FIRSTLY - Written copy of oral representation delivered by Stuart Shearer at the Open Floor Hearing at Dunston Hall, submitted at the request of the panel leader. The covering note identifies two factual corrections made since delivery and lists subsequent written submissions. The speech text is unchanged from what was delivered.

East Pye Solar — EN0110014 | Open Floor Hearing

East Pye Solar — Planning Inspectorate Reference EN0110014

Subject: Response to EXAM/9.1 — Request to Include Hawes Green Heritage Cluster and Market Lane in the Accompanied Site Inspection Itinerary for Site 8

Drawing file: published-documents / EN0110014-000148-6.2.7.6 Environmental Statement Volume 2 Figure 7.6 Visual Receptors Plan.pdf

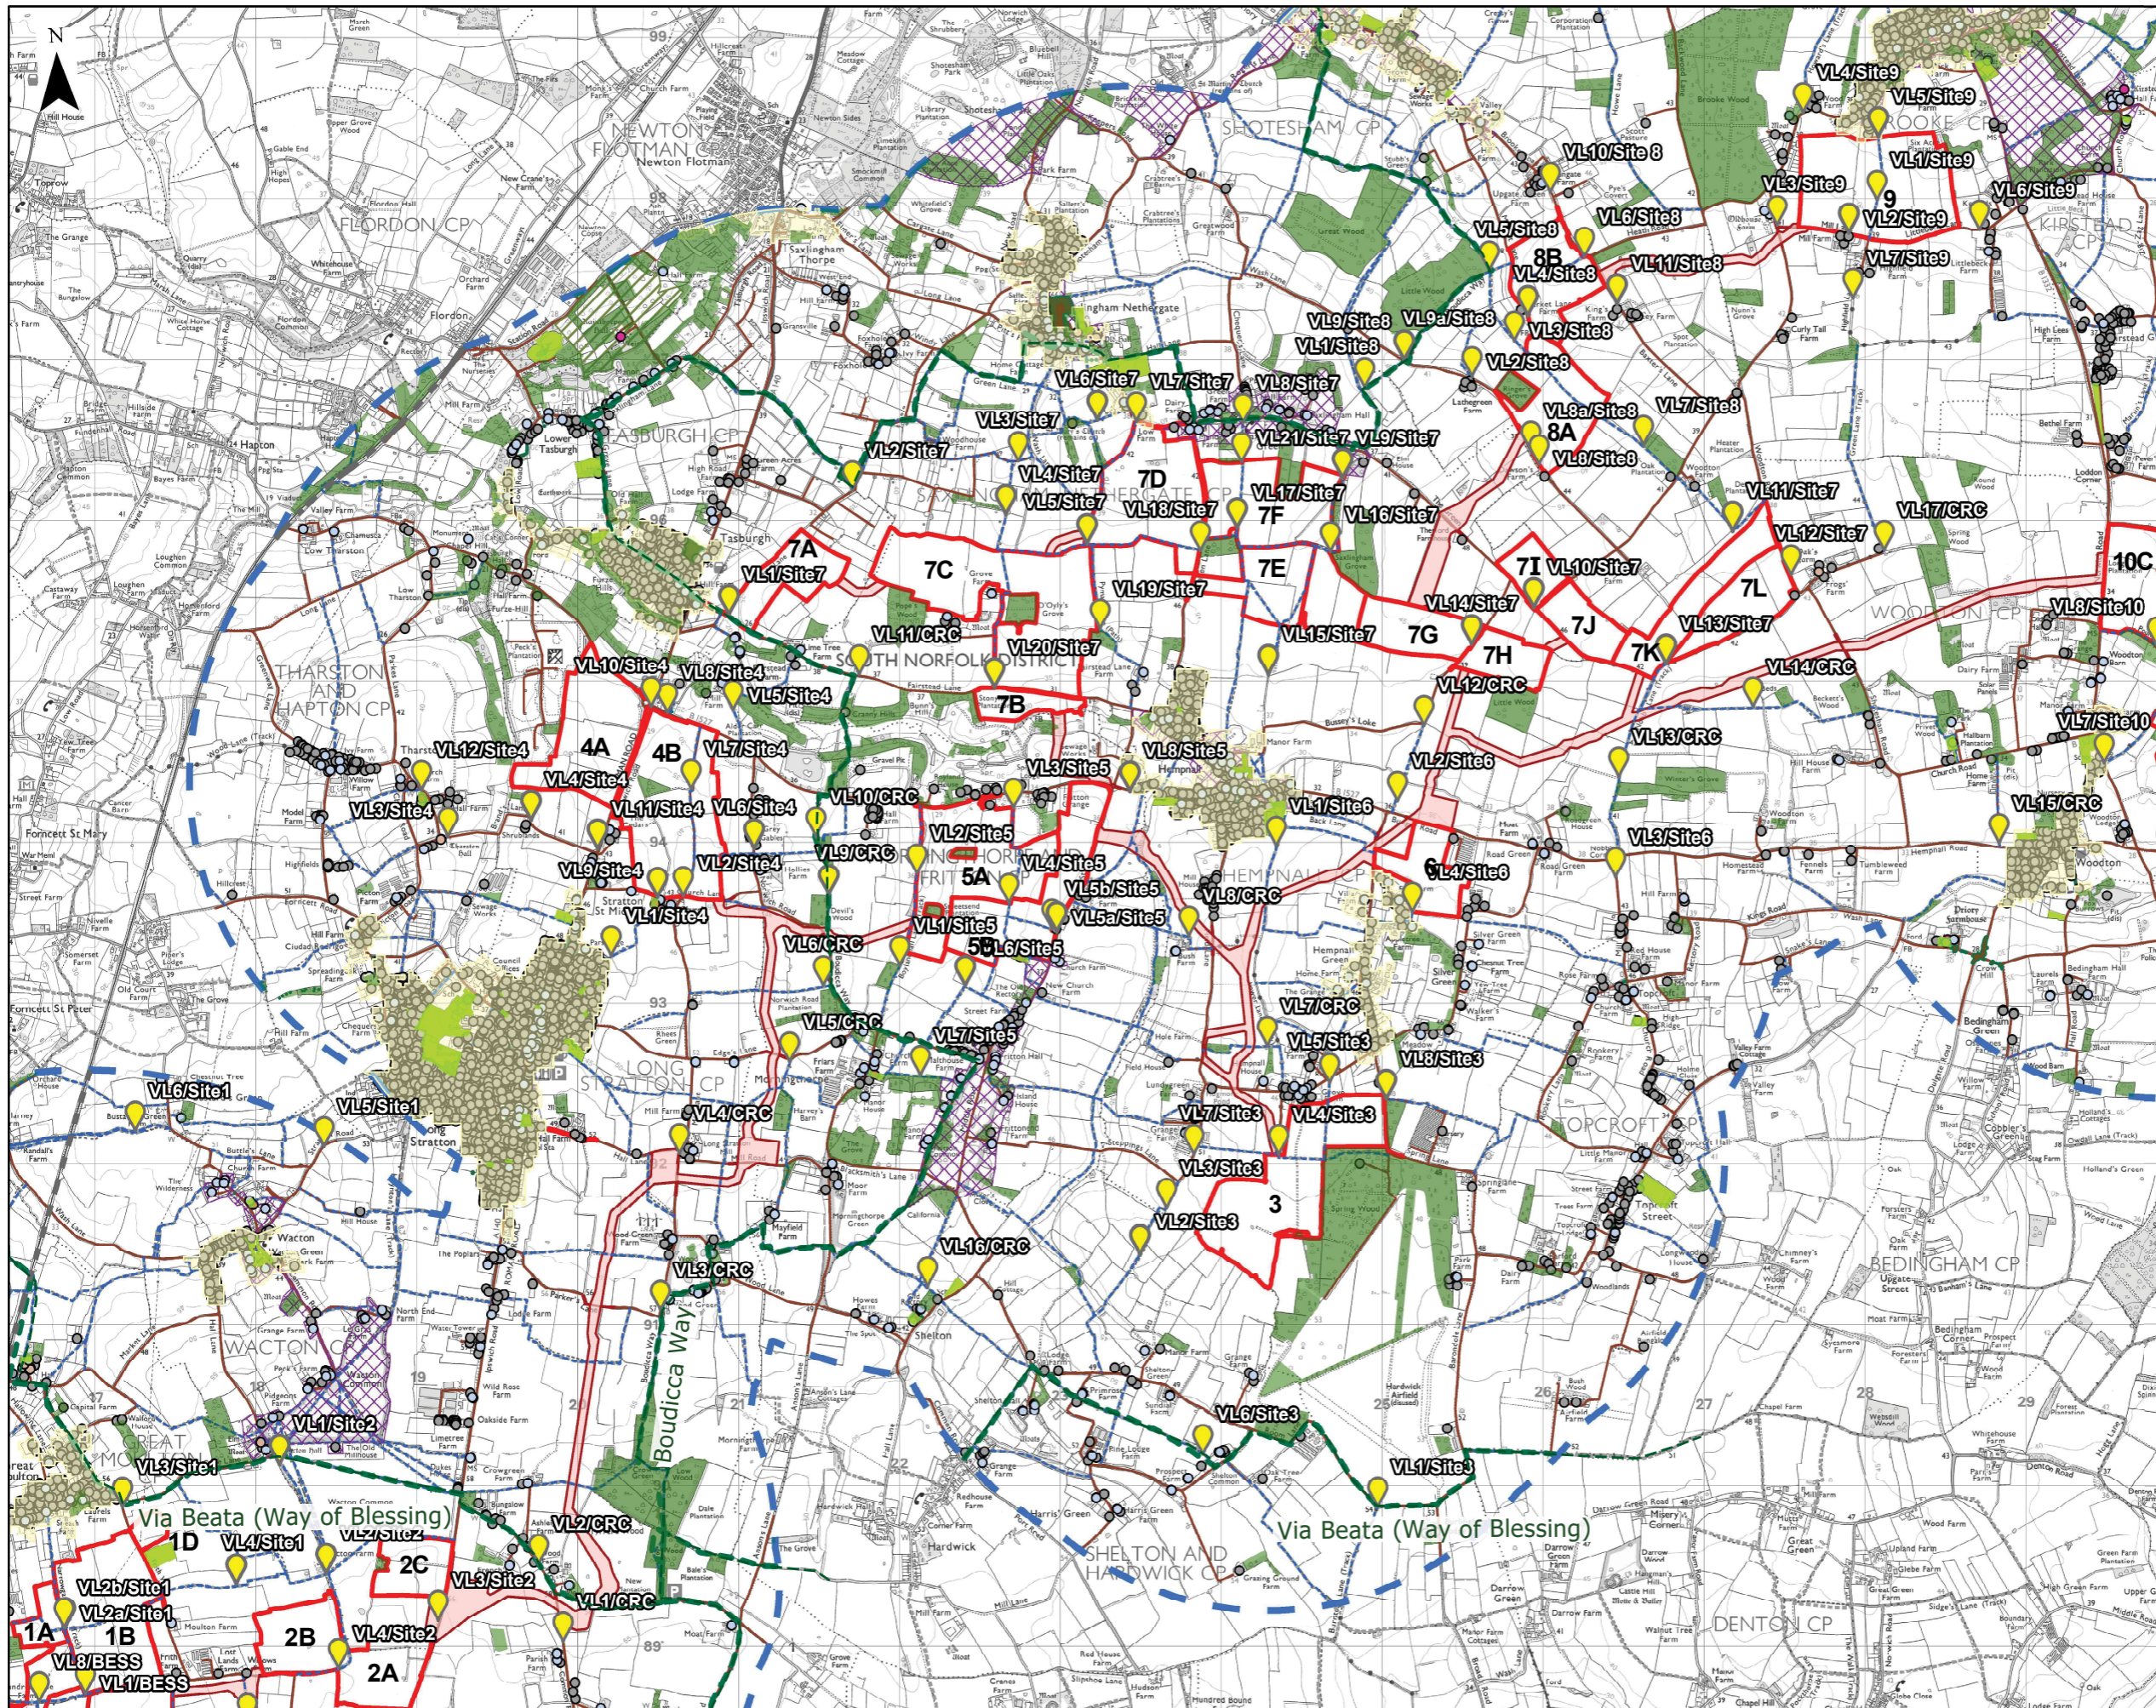
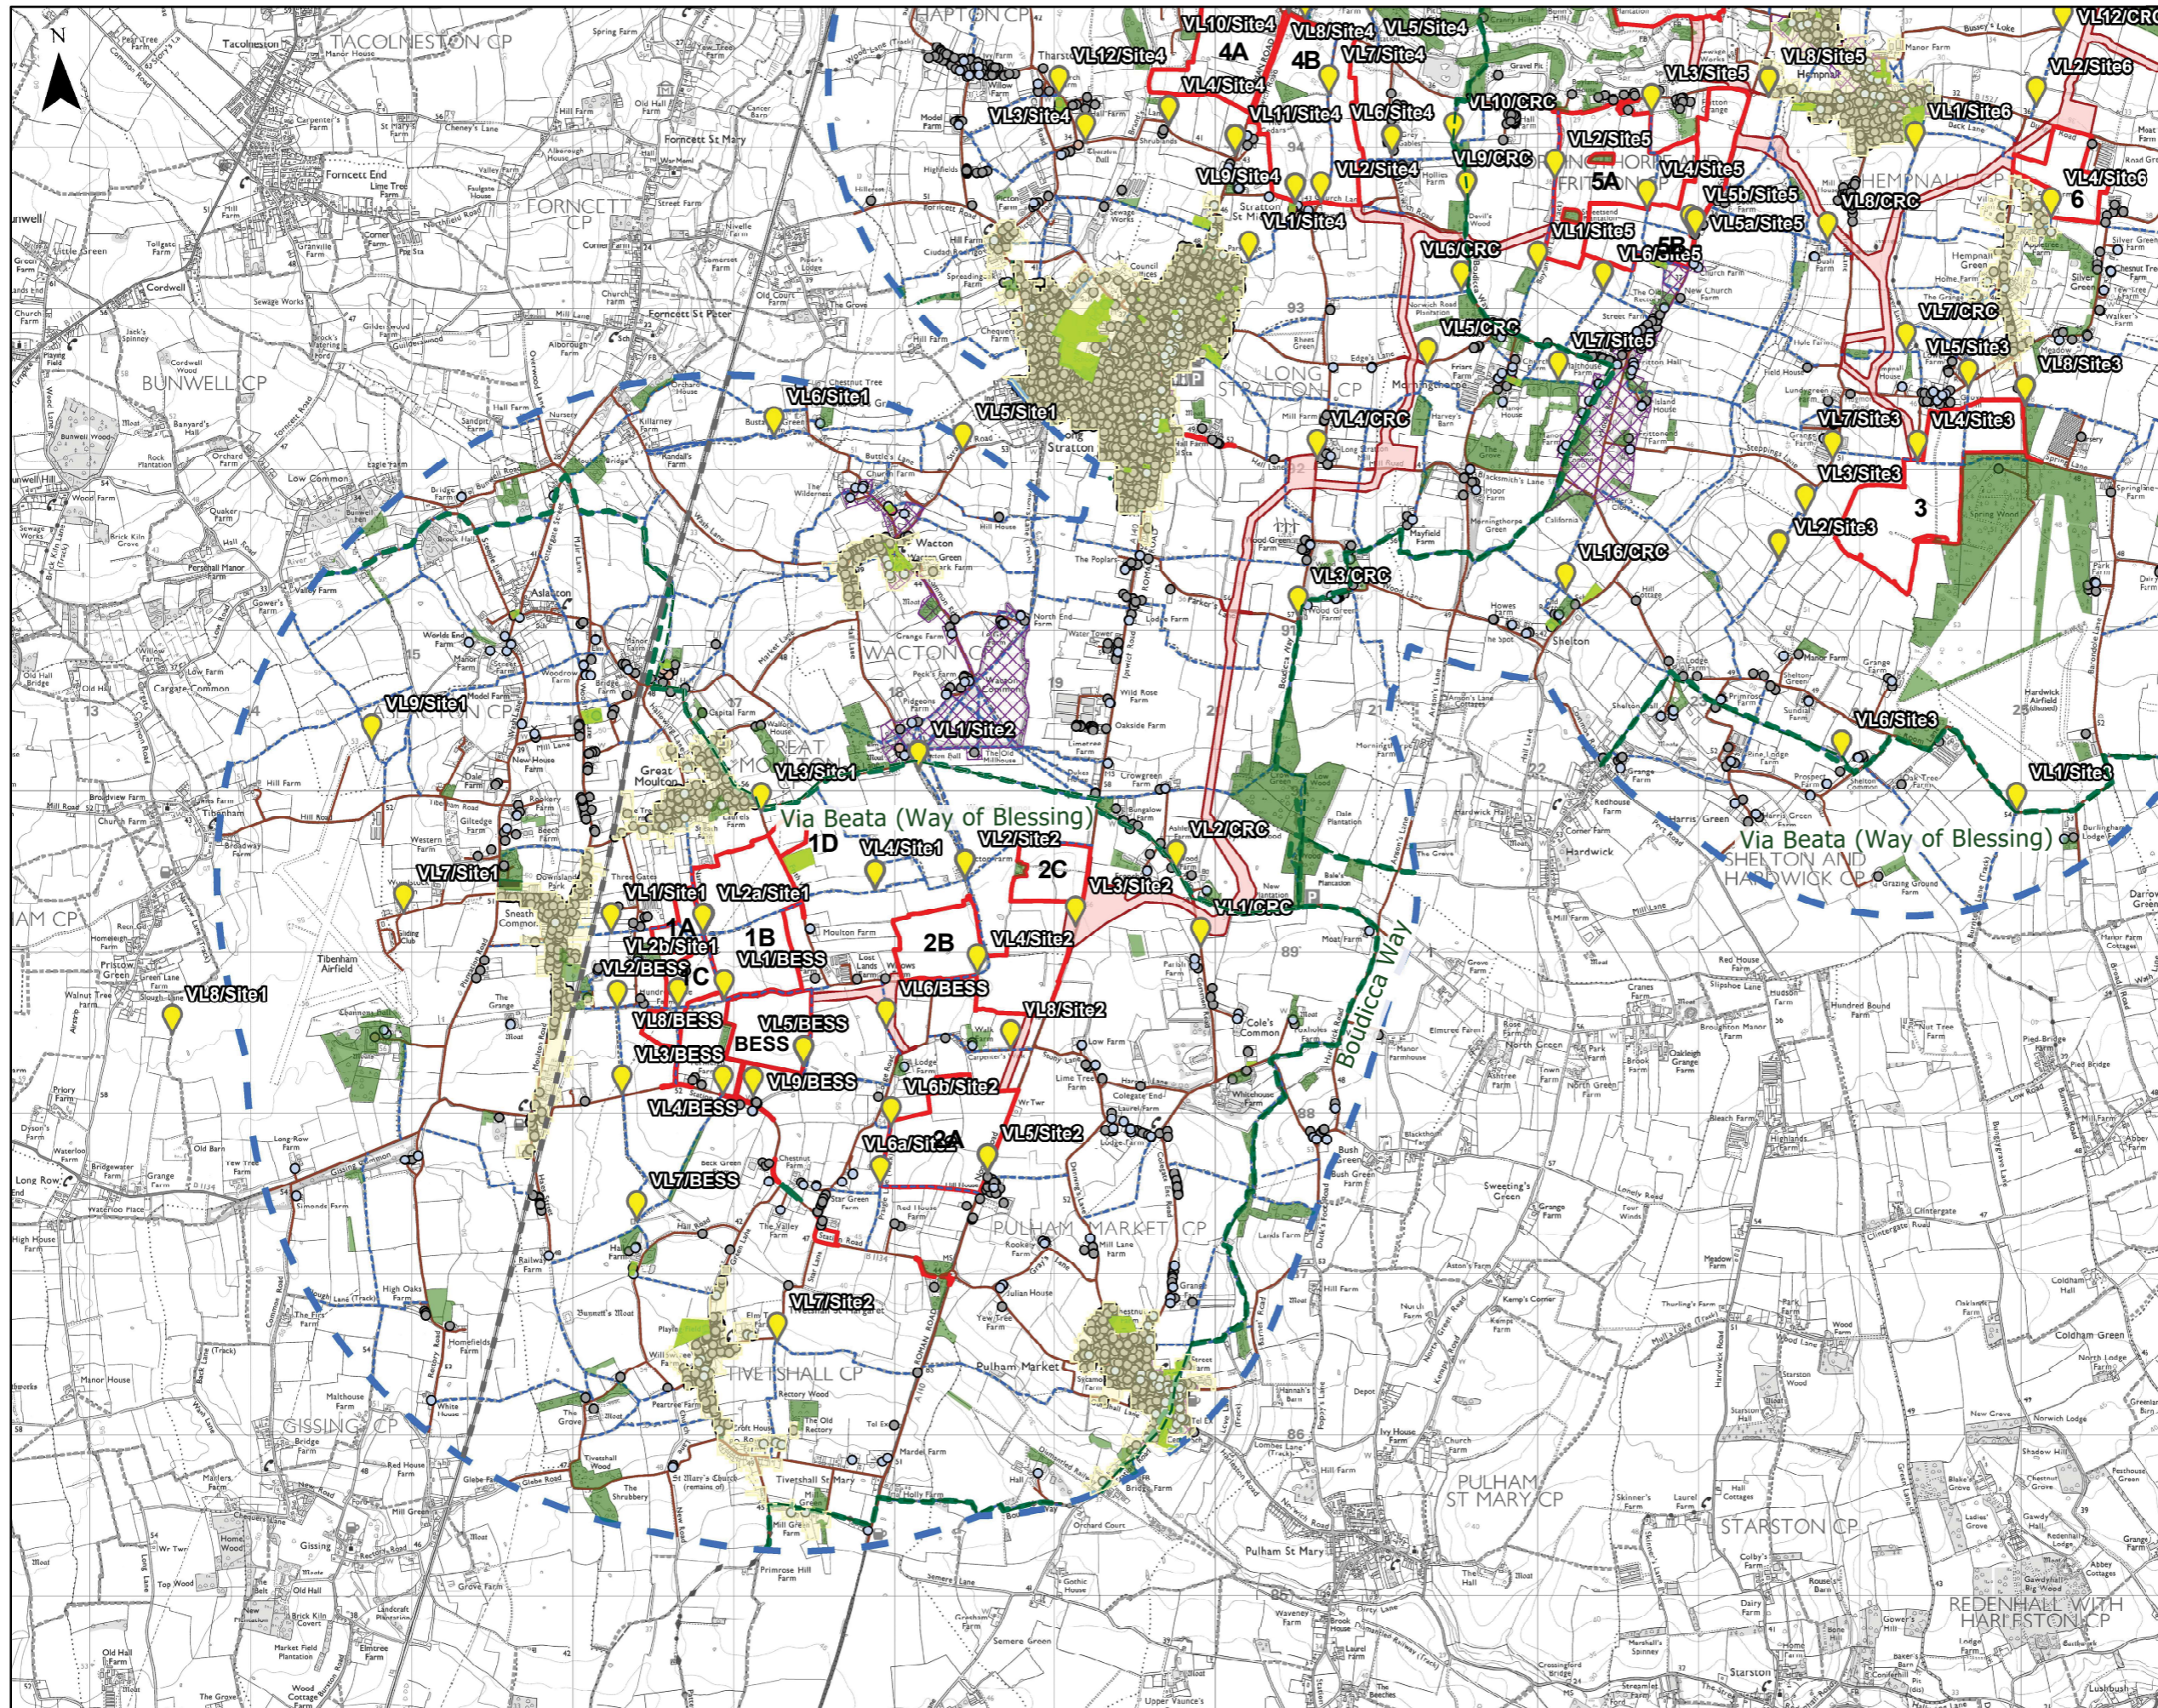
First — in Appendix 7.4, the visual receptor on our ridge is listed as a commercial holiday lodge called Highfield Lodge Holiday Home. It does not exist. The property is a permanent residential home — Highfield House — sitting within our heritage cluster. Their own masterplan maps then place that same property off Highfield Road in Brooke — over 3 miles from St Mary's Church as the crow flies. The developer's surveyors have placed the most sensitive receptor in the vicinity of Site 8 more than 3 miles from where it actually stands. The result is that the most sensitive residential and heritage receptor cluster near Site 8 has been erased from the visual assessment entirely.

First — in Appendix 7.4, the visual receptor on our ridge is listed as a commercial holiday lodge called Highfield Lodge Holiday Home. It does not exist. The property is a permanent residential home — Highfield House — sitting within our heritage cluster. Their own masterplan maps

then place it off Highfield Road in Brooke, over a mile away. The result is that the most sensitive residential and heritage receptor near Site 8 has been erased from the visual assessment entirely.

One — the Applicant corrects both Highfield errors and reassesses the visual impact on our cluster.

One — the Applicant corrects both Highfield errors and reassesses the visual impact on our cluster.
